Please ask for: Ms Iqraa Malik
Email: iqraa.malik@terraquest.co.uk
Telephone: 01212341390
Our Ref: LU/72/21/PL
Your Ref:
Date: 18th March 2021

Application for Planning Permission

Development: Single storey infill side extension
Location: Ground Floor Flat 2a Parkside Avenue Littlehampton BN17 6BG

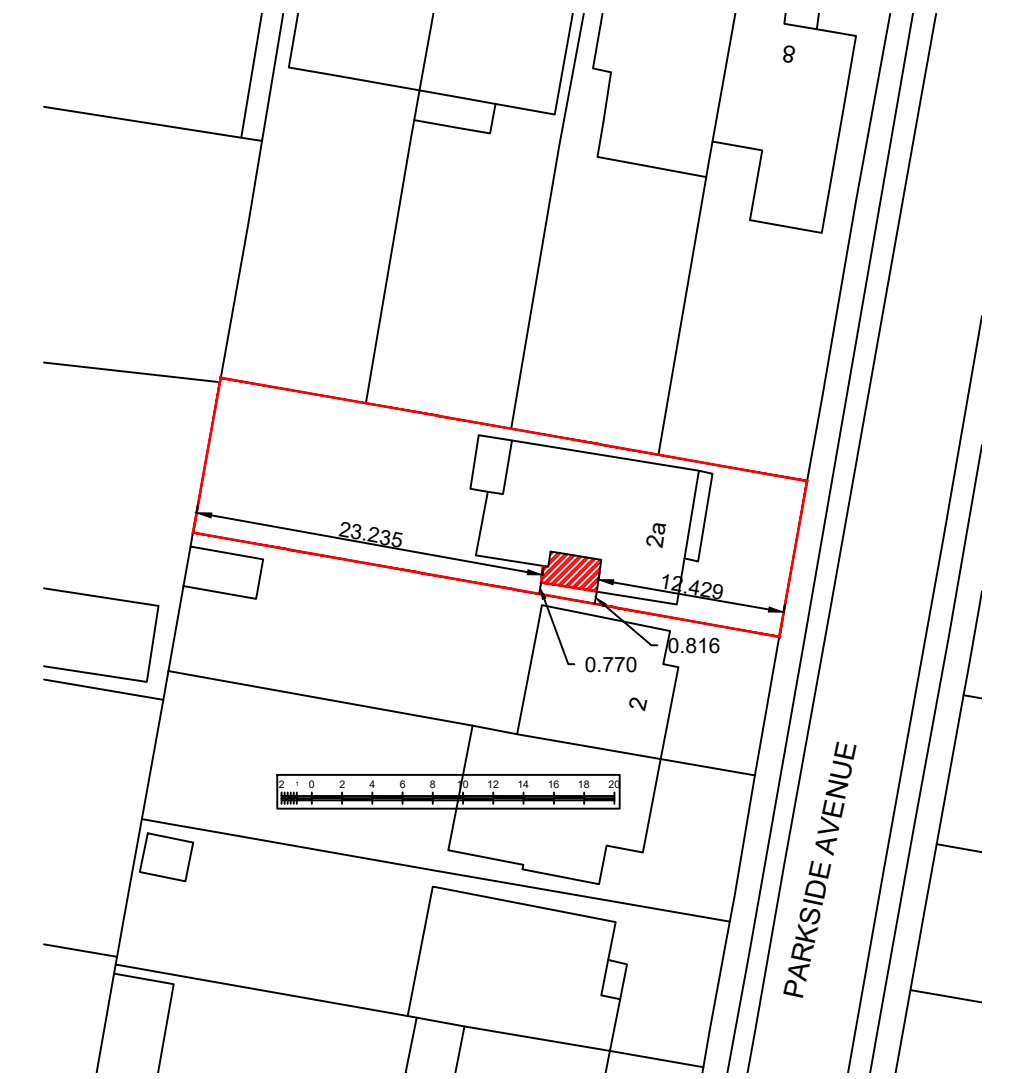
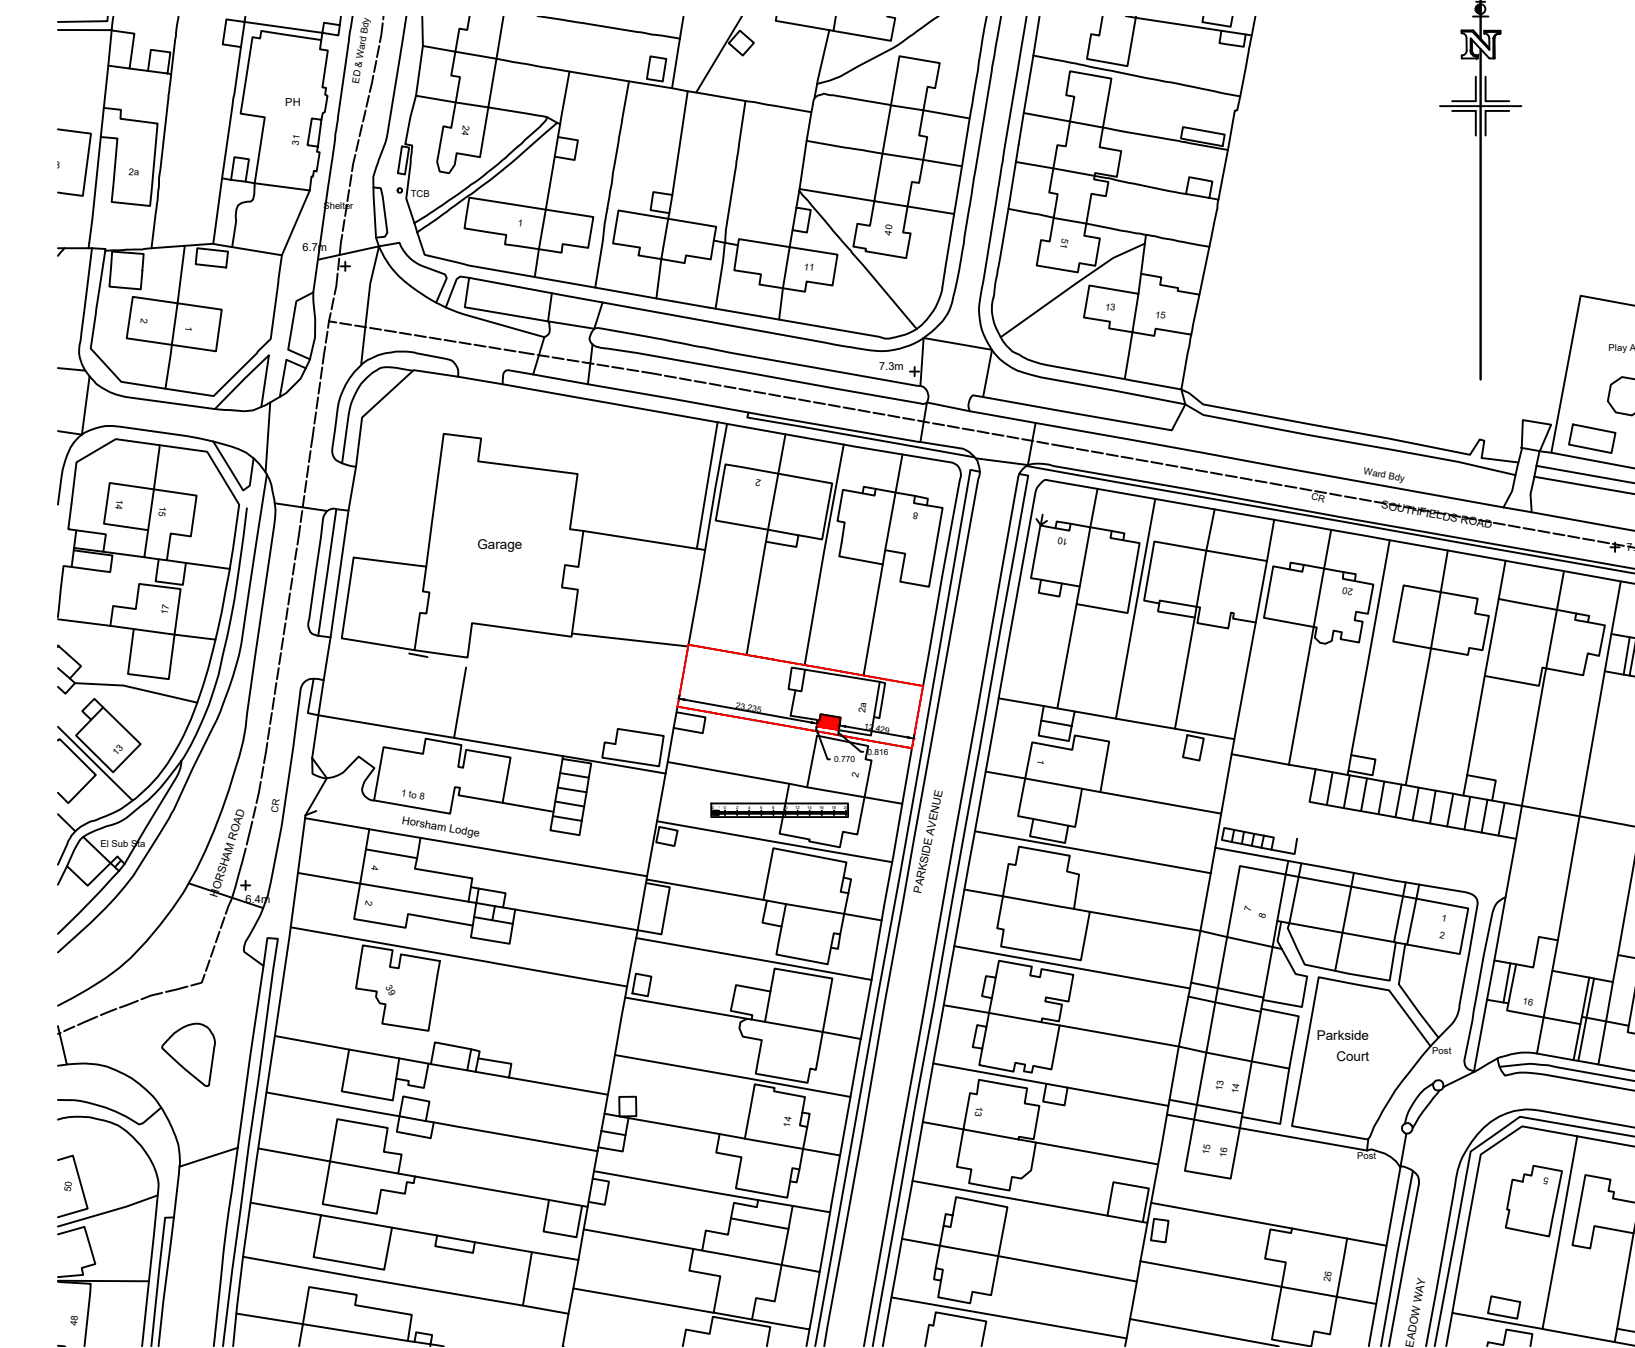
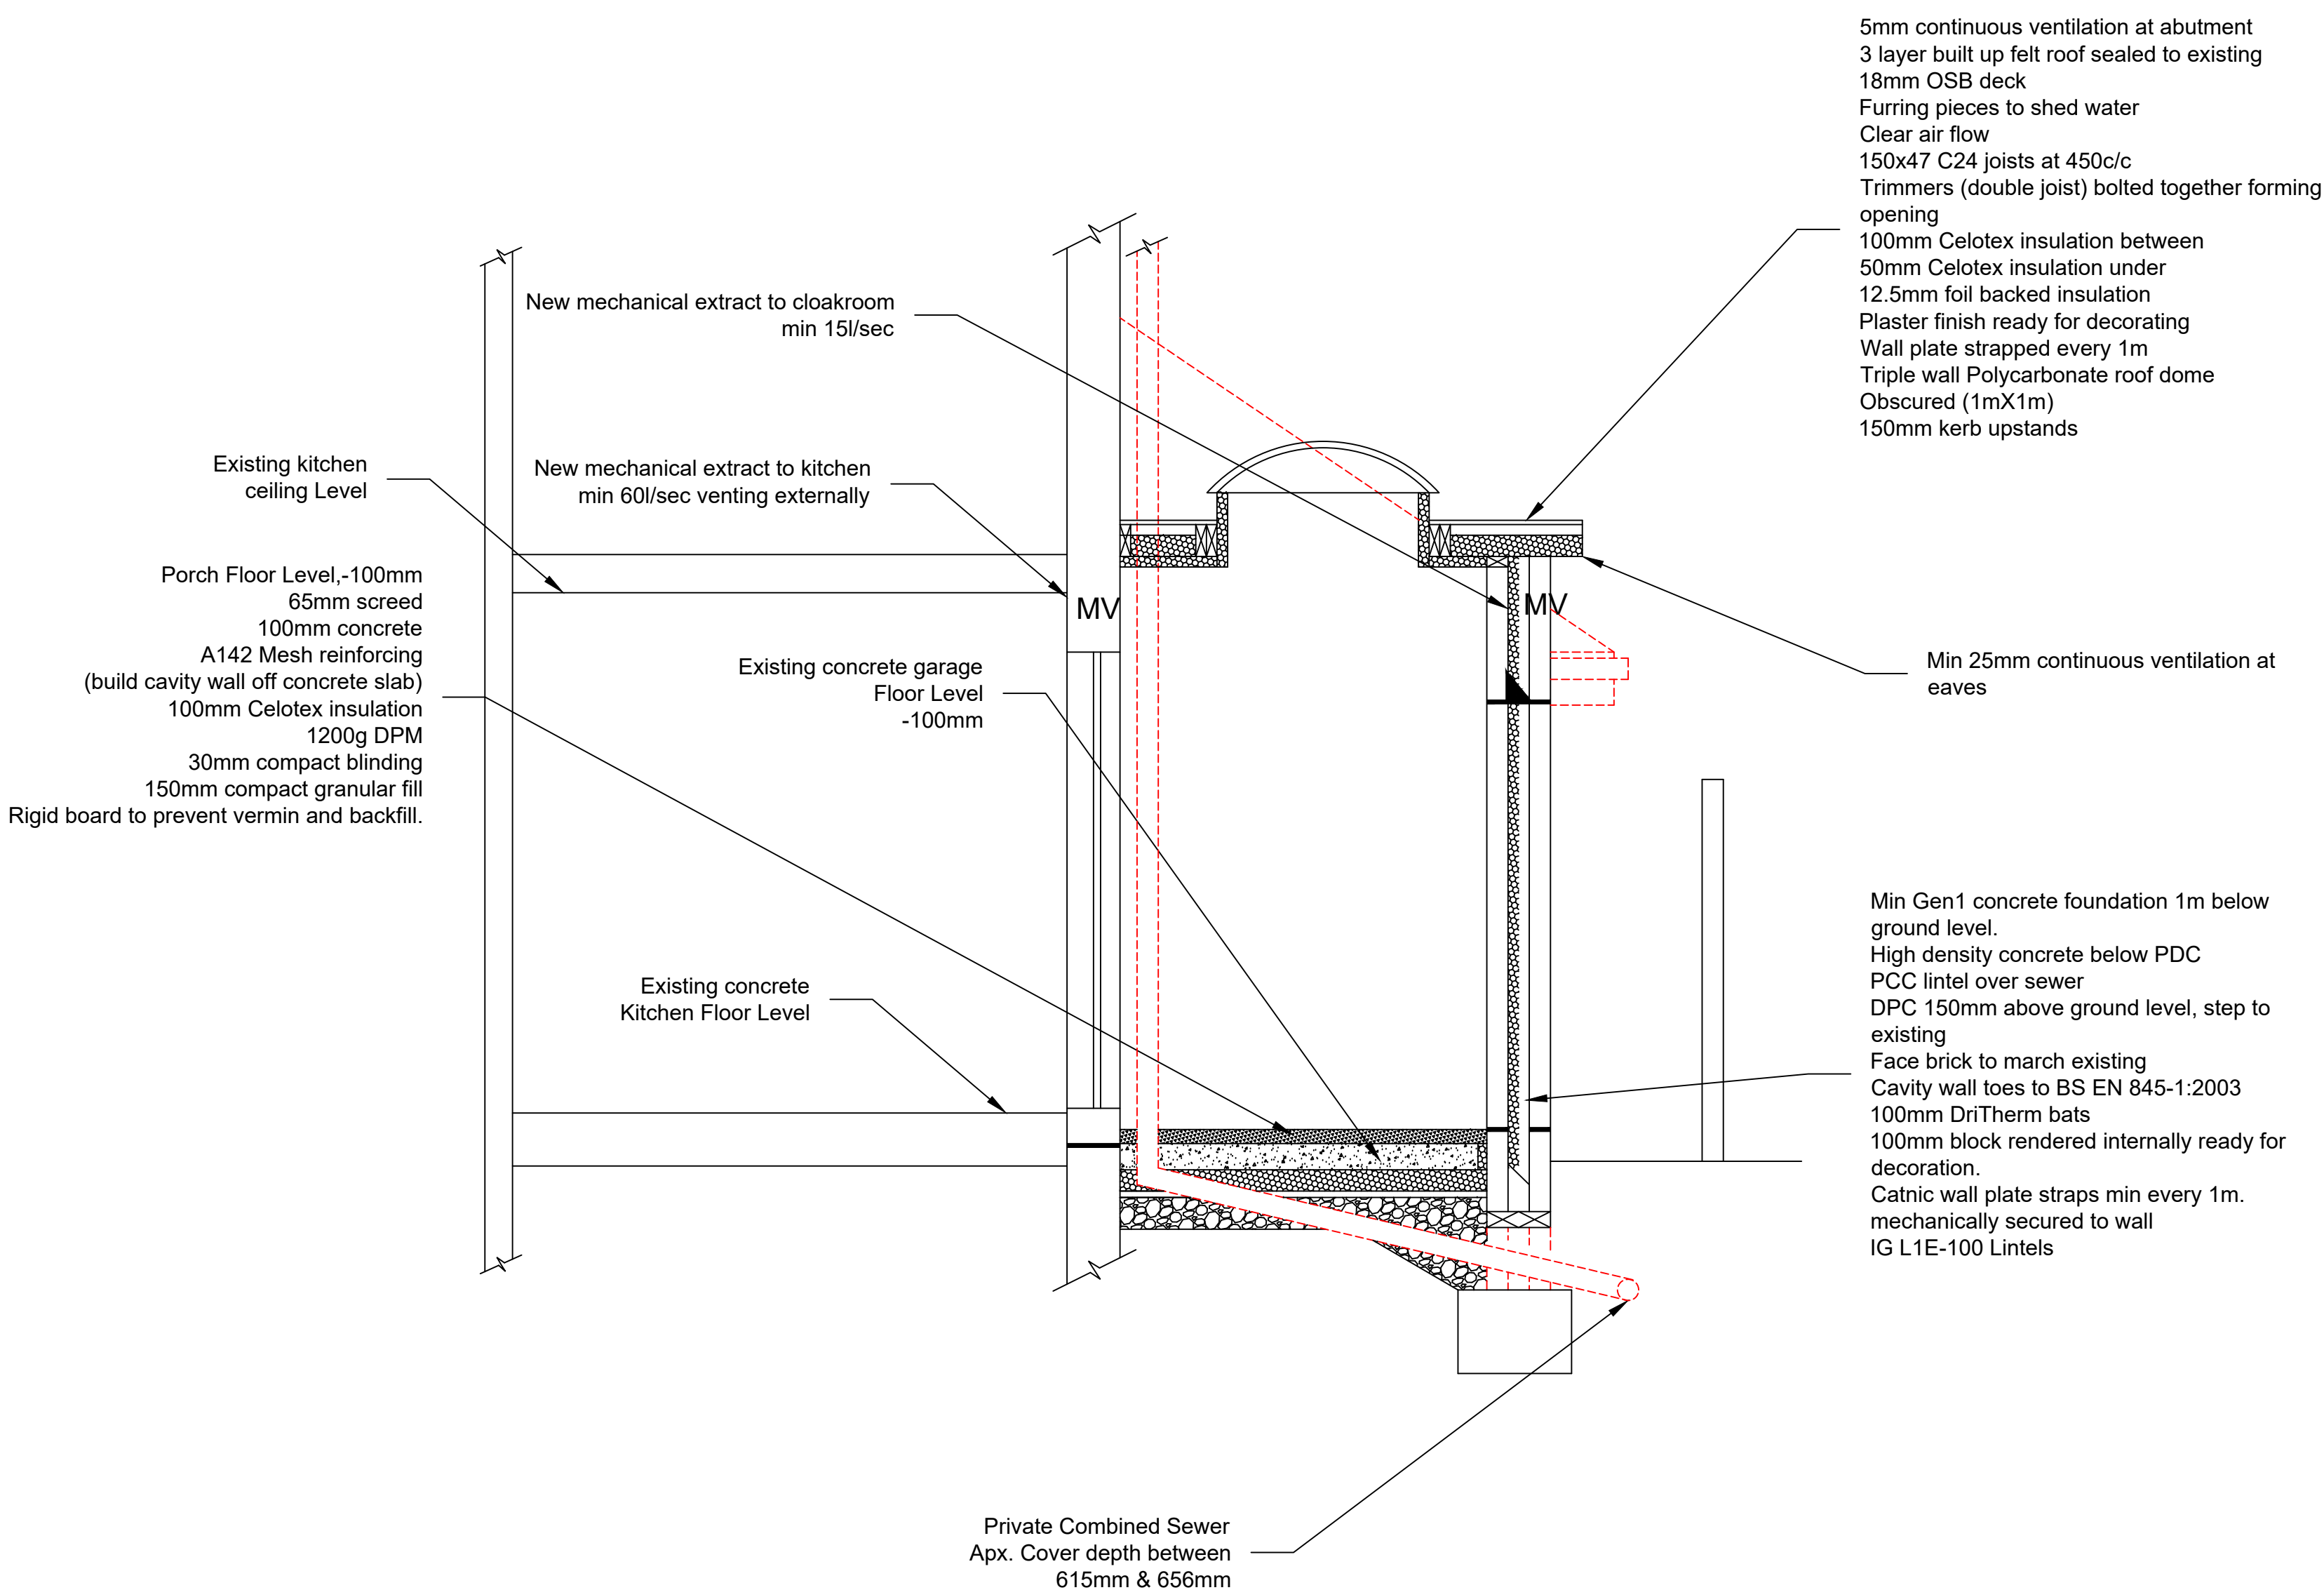
Scale Bar: You are required to submit a scale bar on all plans.

Dimensions: You are required to include dimensions on the block plan from the proposed extension to all site boundaries.
